Planning Services Sign Permit Review Form

SIGN 2103-0001
DBAIN@ALPHASIGNSNC.COM

Date of Submittal	Application Number	Applicant	Landowner
3/15/21	SIGN 2103-0001	Alpha Signs & Lighting	CARLETA PAGE
Contact Person	Contact Number	Sign Location	PIN Number
DONALD T. BAIN	(910) 309-8721	855 NC 24-97	9585-50-7470-000

Front Elevation

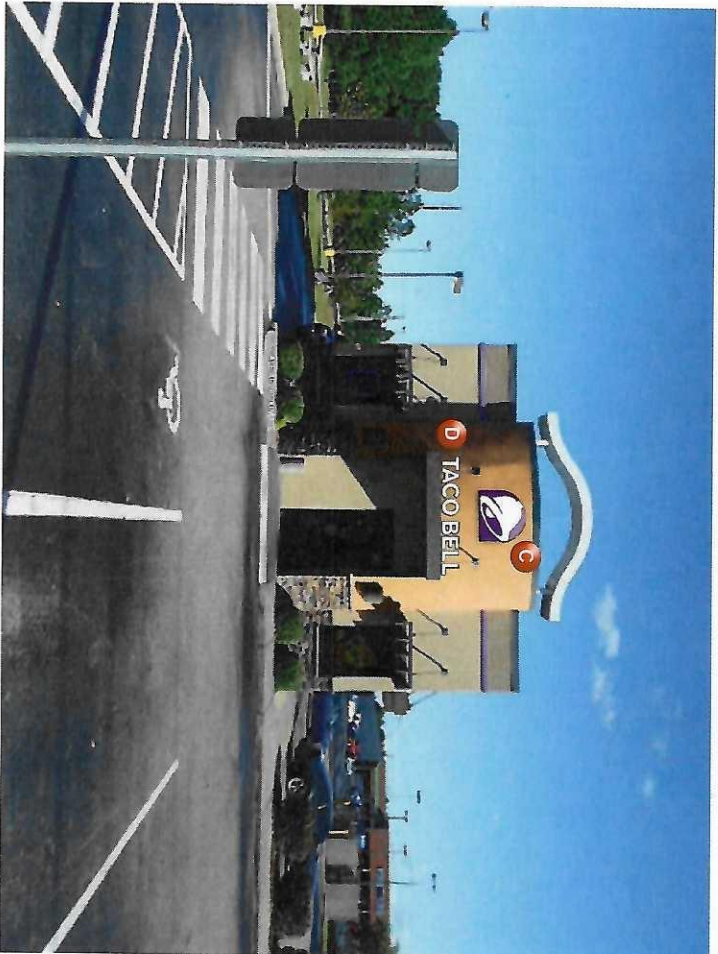
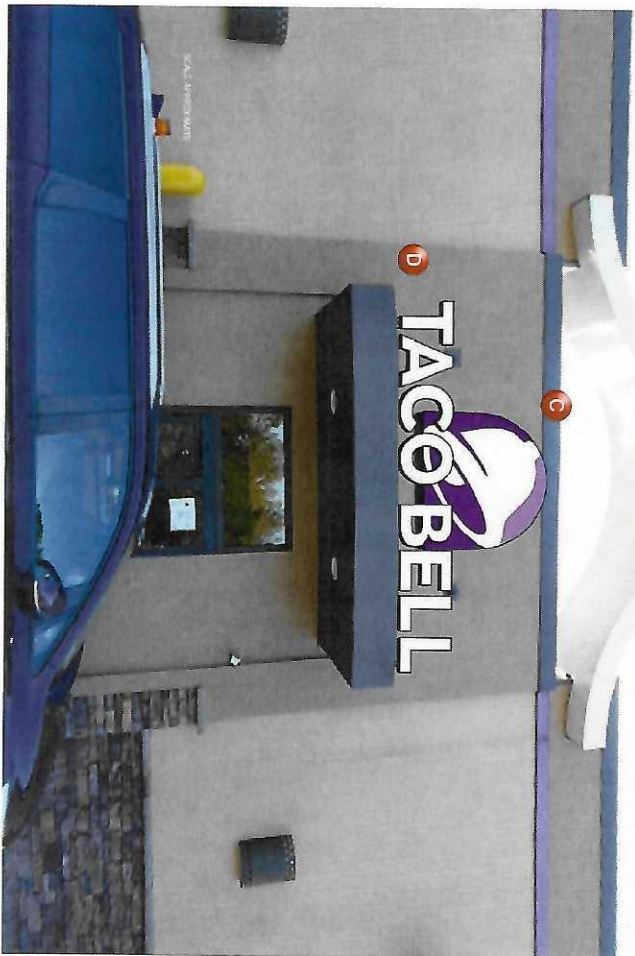
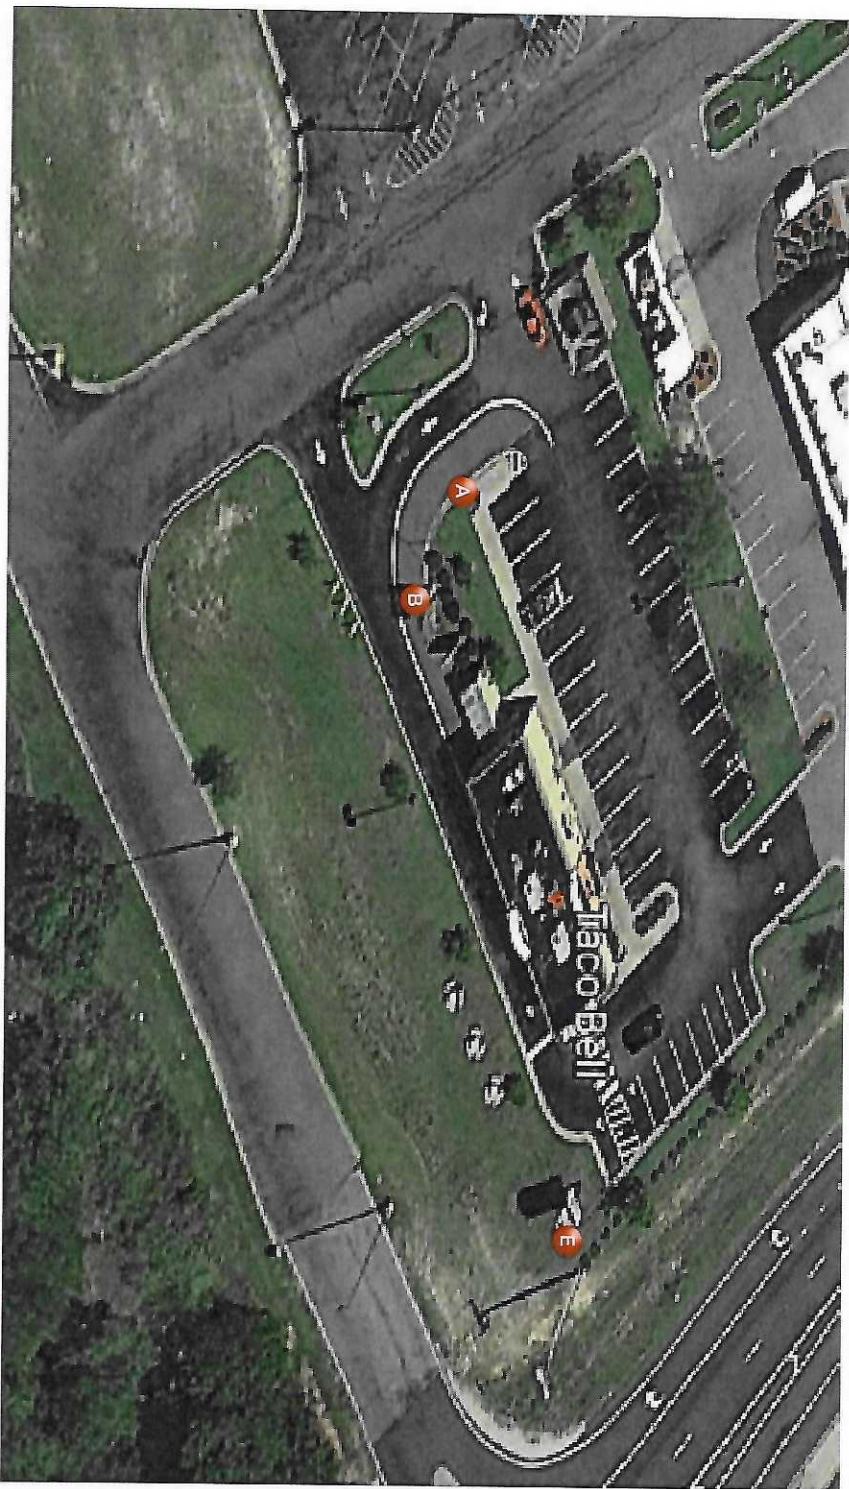
- Check that wall signage is not being increased.
- Email to make sure
- Total # of ~~square~~ linear ft. of mounting walls. Existing wall signage - slope of work
- Need plans we can read (without slant). Specifically pg 9.
- Start w/ something we can read ✓

Drawn #2.
 1. Wall signs: 13.41 sq ft sign per side
 2. Take BELL on hallway: 10'11" x 11'6" = 11.95 = 25.26 sq signage per wall length: 28 + 72.5
